Kittitas County Community Development Services;

RE: VA-21-00003

SITE PLAN

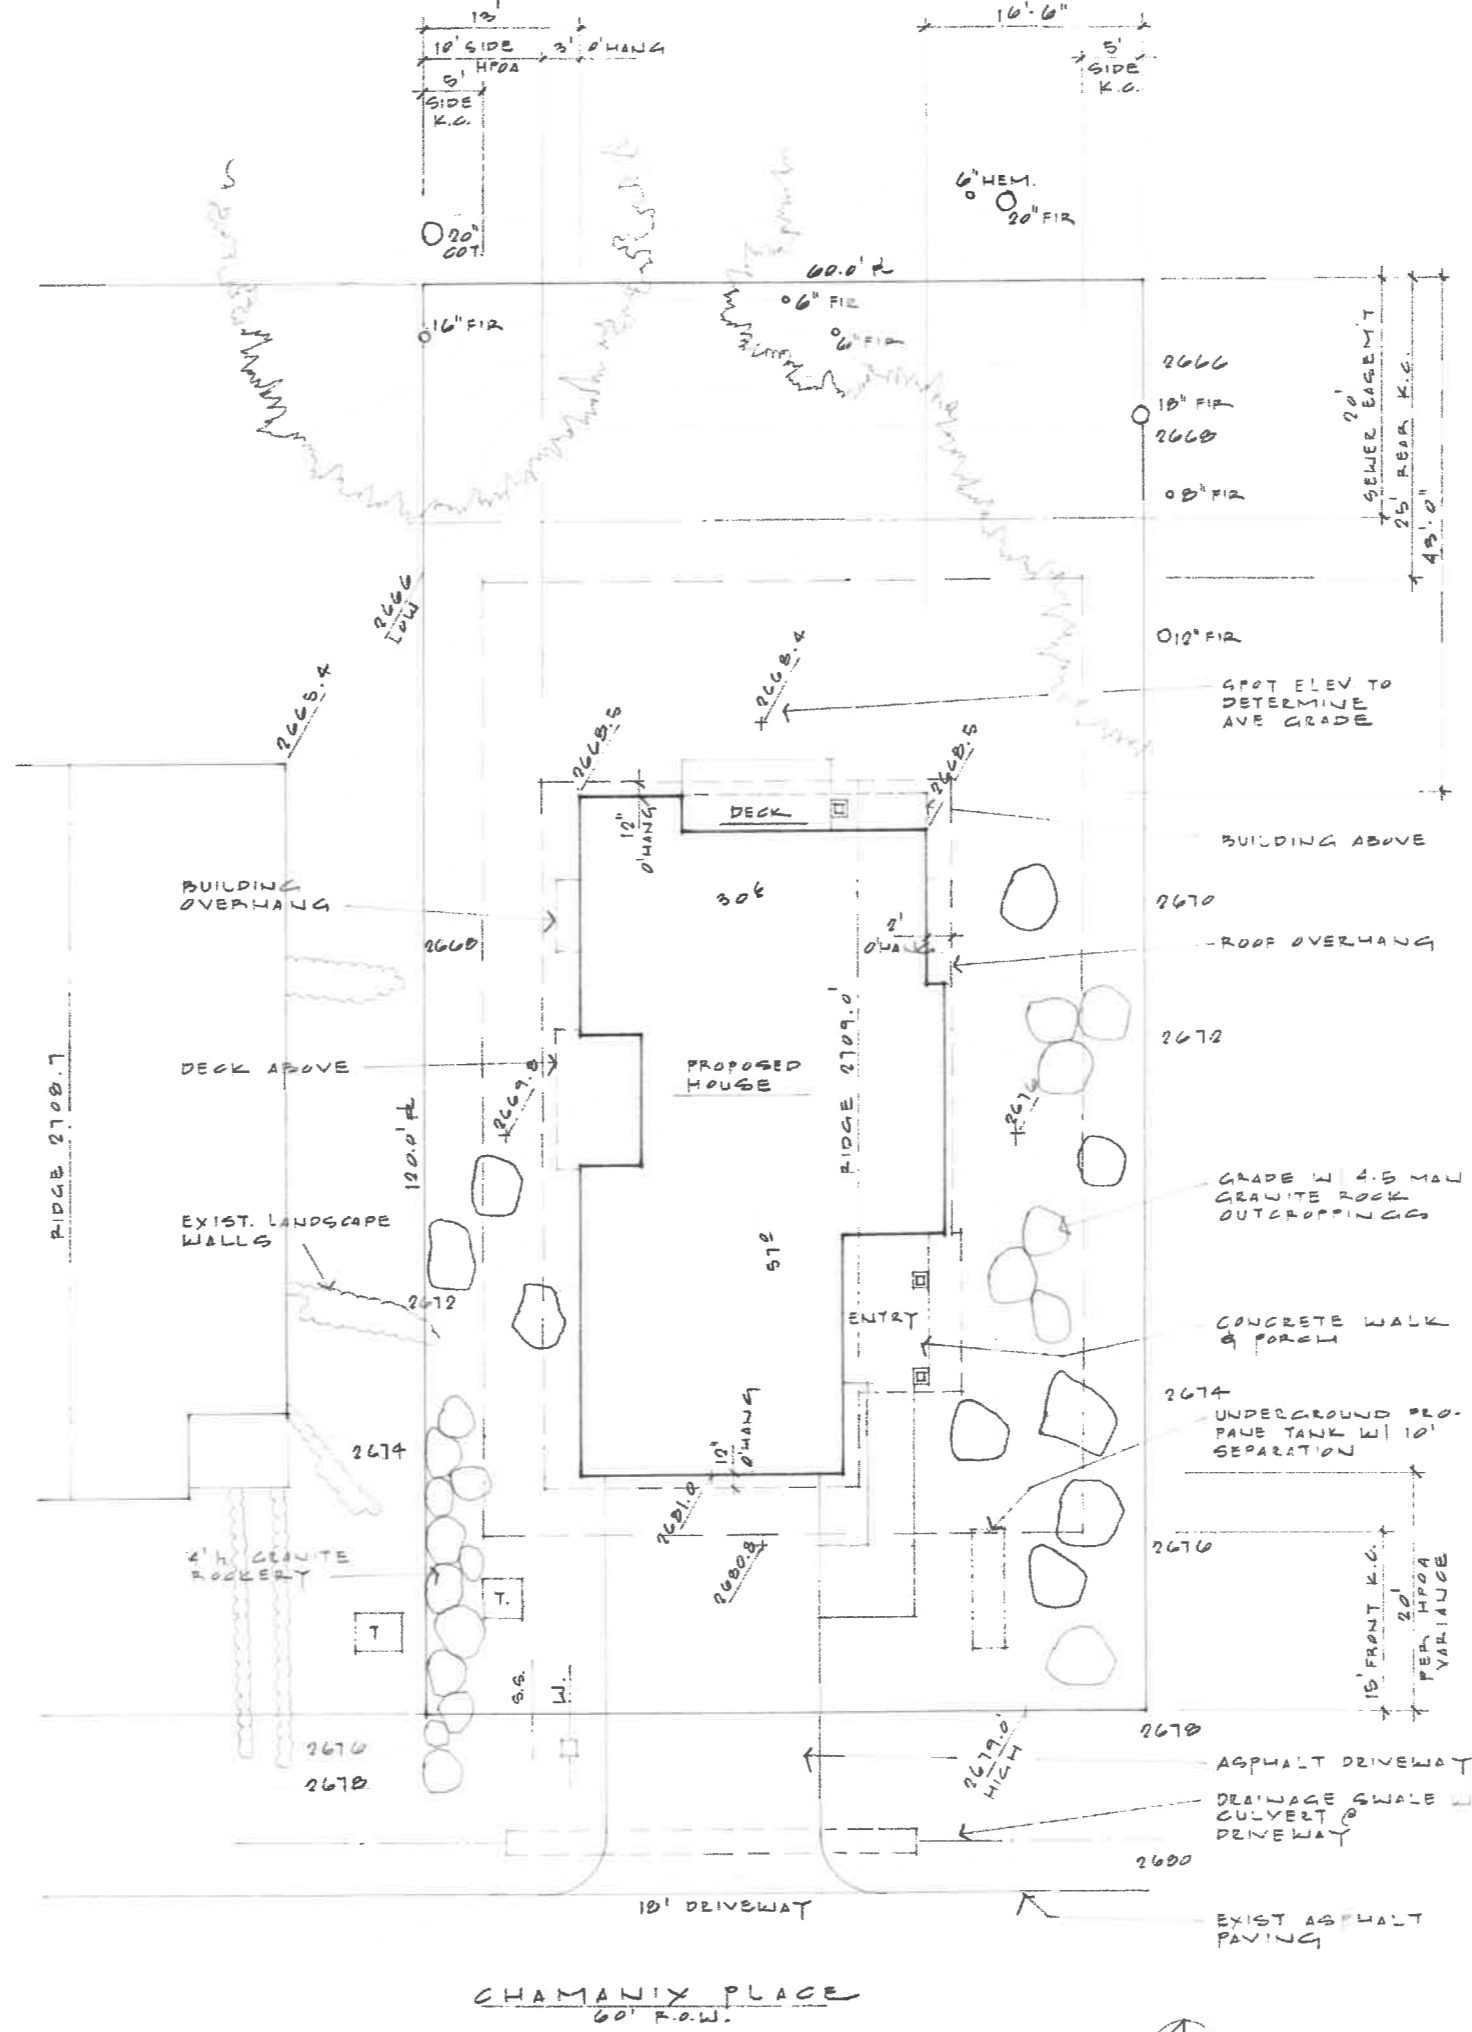
Please Maintain the 25' Setback requirements for All properties within the Hyak Estates, it is imperative that snow storage space be allow for County snow removal.

Current snowfall is 412", with the Snow banks at 10' Tall or higher on Chamonix Place, March and April still to come.
